Site plans - building permit

Dominic, Pat, Adam,

CONSTRUCTION MANAGEMENT PLAN
UPDATED [11-05-18]

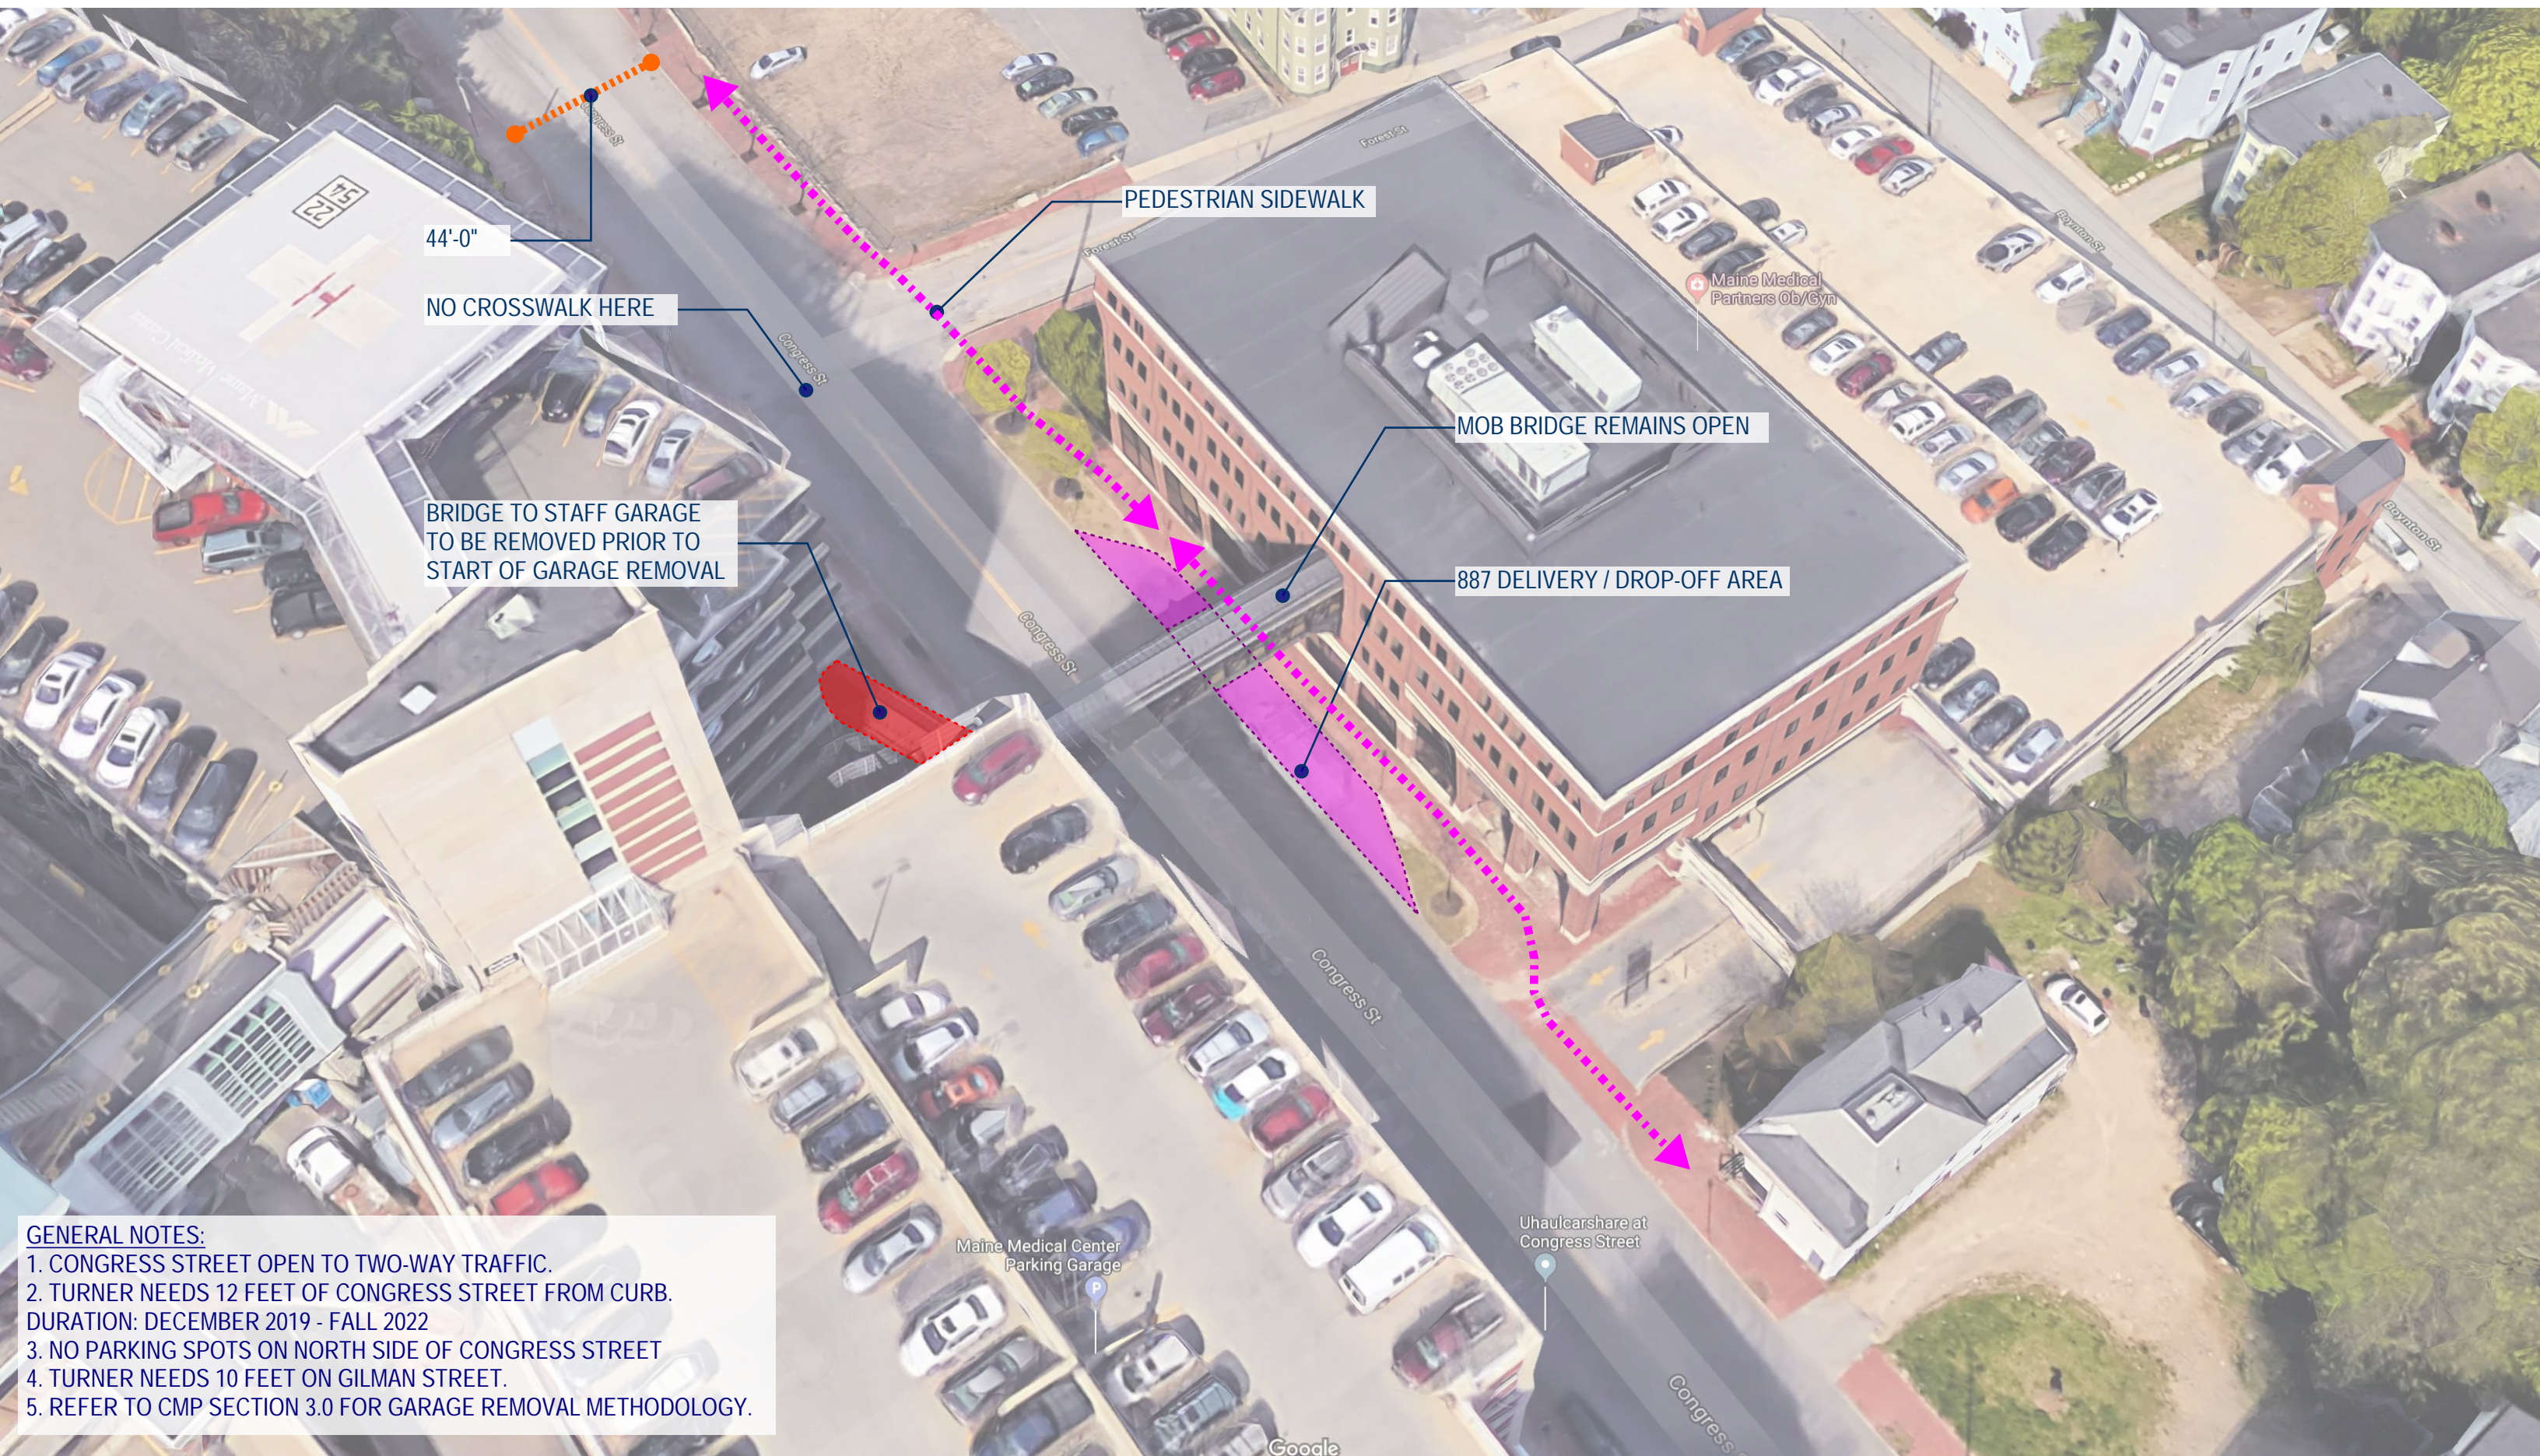
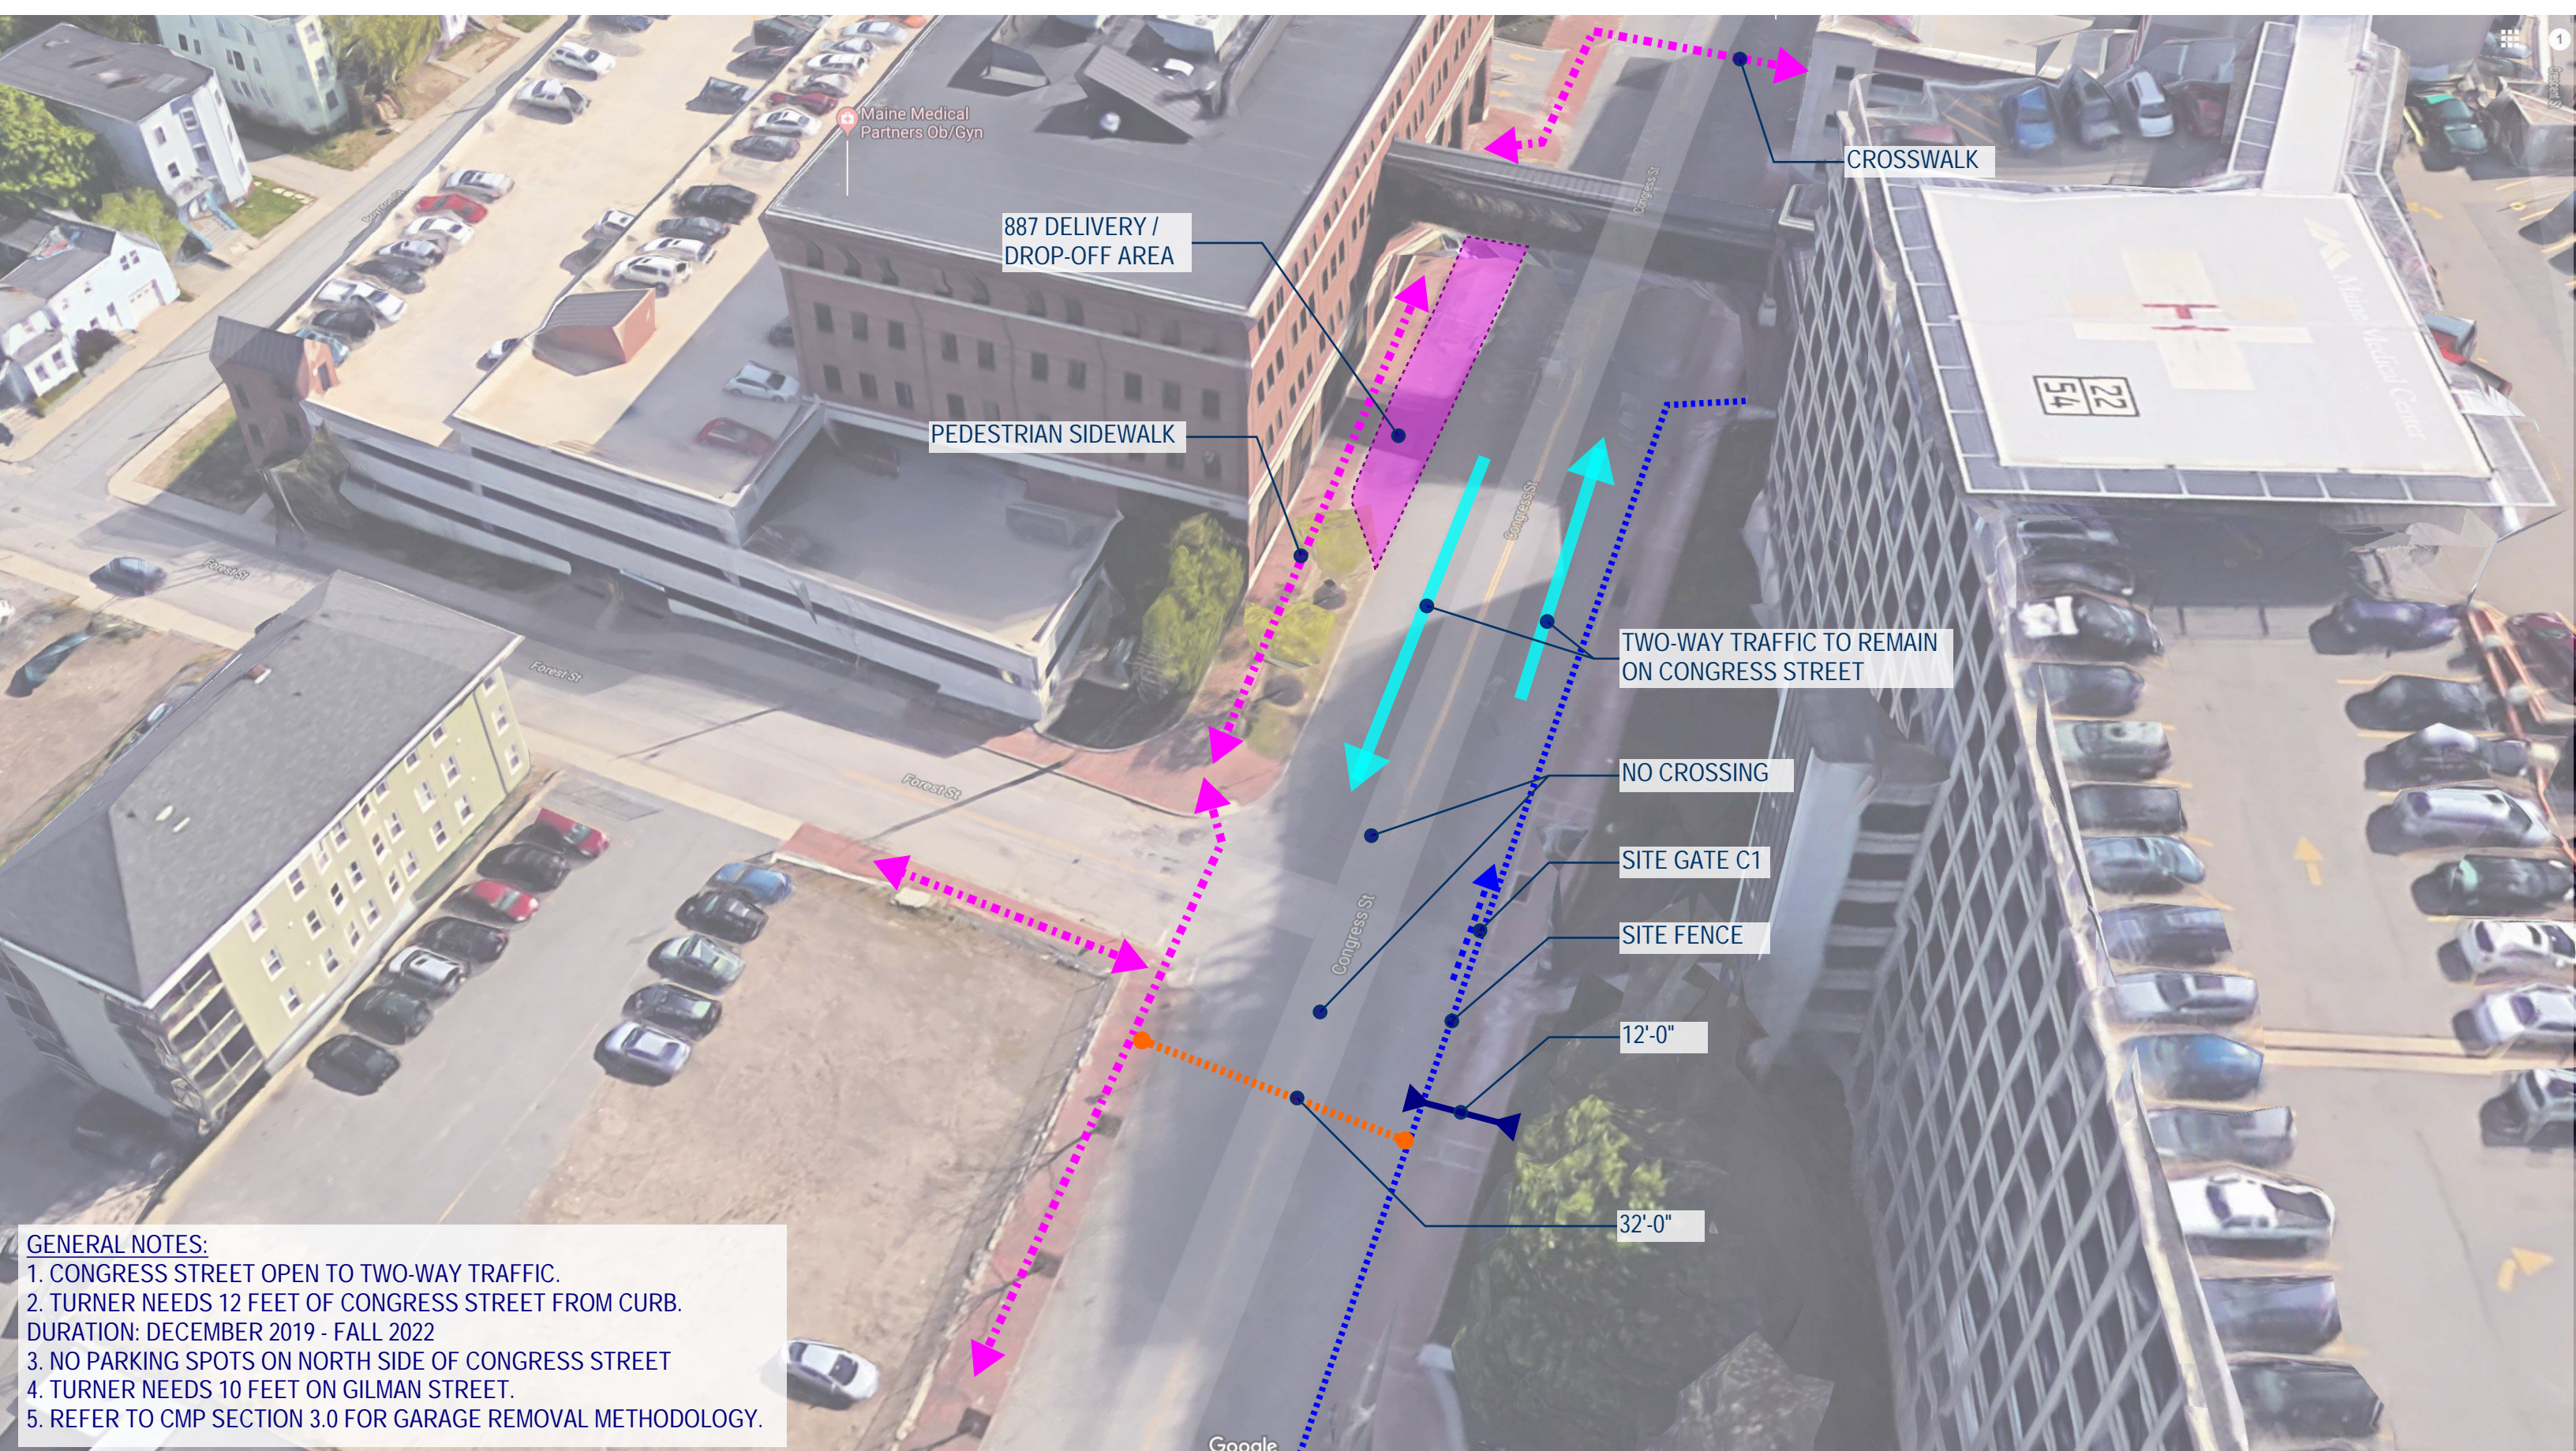
We also have no updated logistics plan since the original CMP submittal in November 2018. There are references to logistics plans in the CMP you've provided here, but no attachments. (See the latest version that we have (not including the package for the enabling work) attached.) Can you provide updated logistics plans if there are any?

It is recommended that further discussion on the duration of the Congress Street sidewalk closures be included. Supplemental pedestrian safety devices will be required during the sidewalk closure time period (to safely cross pedestrians for the sidewalk detour).

All sidewalk detours shall be ADA compliant.

Changes to the lane configuration on Congress Street west of Gilman Street is likely and may need to be included in the plan.
